From: Iqraa Malik [REDACTED]
Sent: 03 July 2020 [REDACTED]
To: Sian Eggington [REDACTED]
Subject: FW: Request for further information EP/73/20/HH
Attachments: We sent you safe versions of your files; 1444P02E.pdf

BLOCK PLAN
Scale 1:500

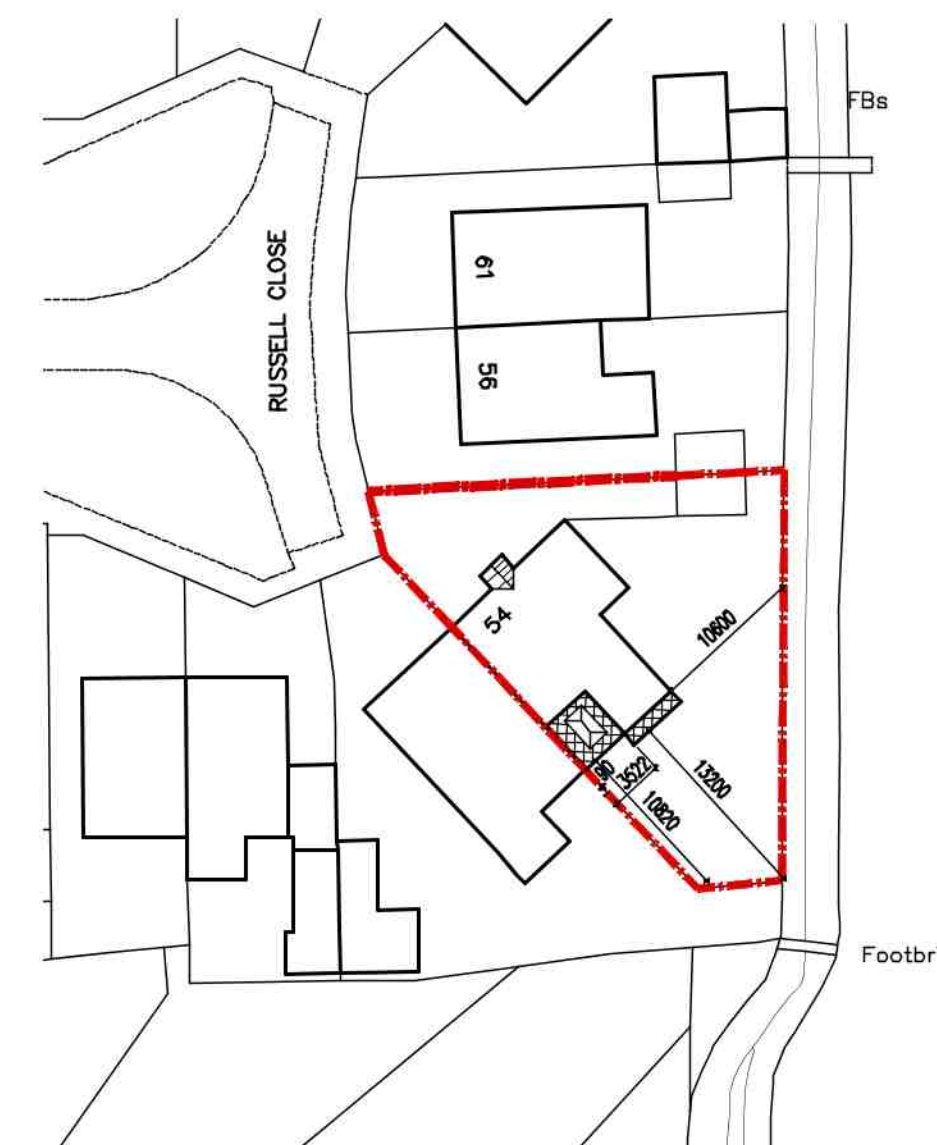
The dimensions are still unreadable. Could you please confirm what they are?

Further to your earlier e-mail please find attached drawing showing enlarged dimensions to the block plan as requested.
